HAYES STRUCTURAL

Re: 25-FTG-153
Footing Deviation
2234 Buckhorn Rd.
Sanford, NC 27330
Permit No.: SFD2410-0018

At your request, the provided information and approved plans were reviewed for the above referenced single family residence under construction to address the footing deviations at the garage door openings.

SHEET: CRAWL SPACE FOUNDATION

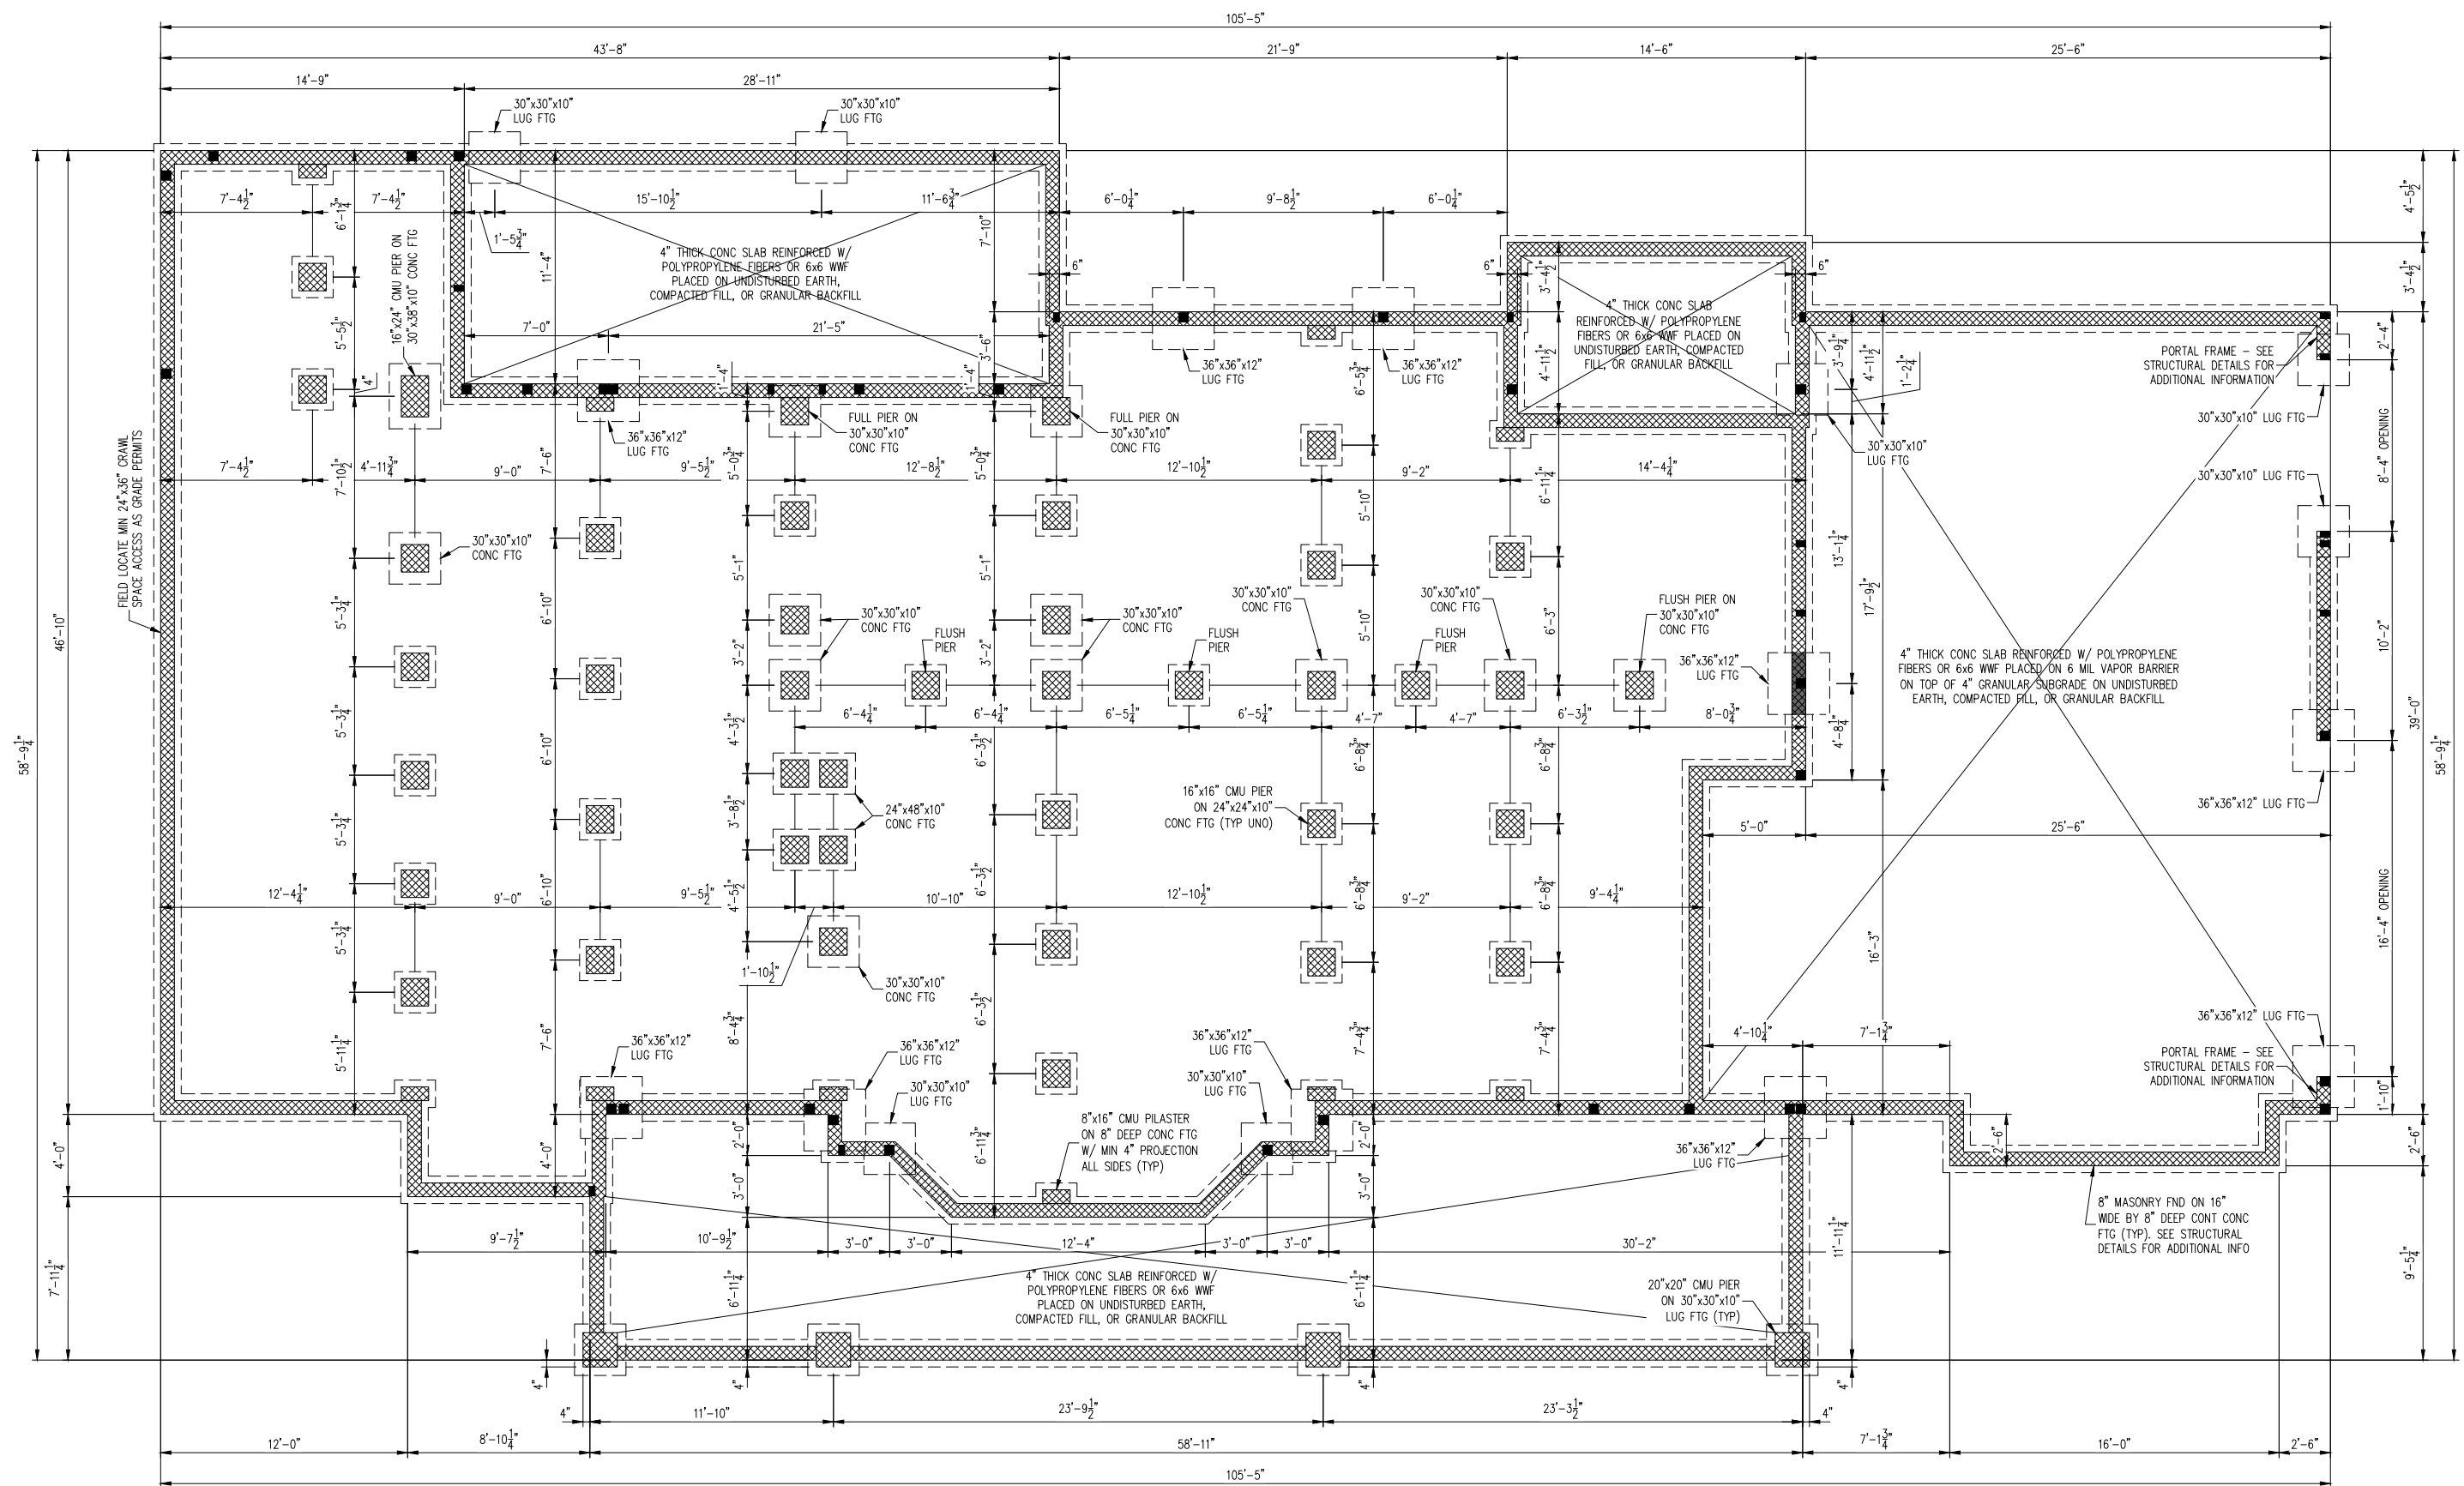
A continuous footing was excavated across the garage door openings. Prior to concrete placement, the plan specified lug footings at each end of the garage door openings were verified to be excavated and prepared per the approved plans.

The "as-built" footing configurations at the garage door openings are adequate and are suitable for concrete placement. The remainder of the footings were verified by a Harnett County inspector and are not included within the scope of this report.
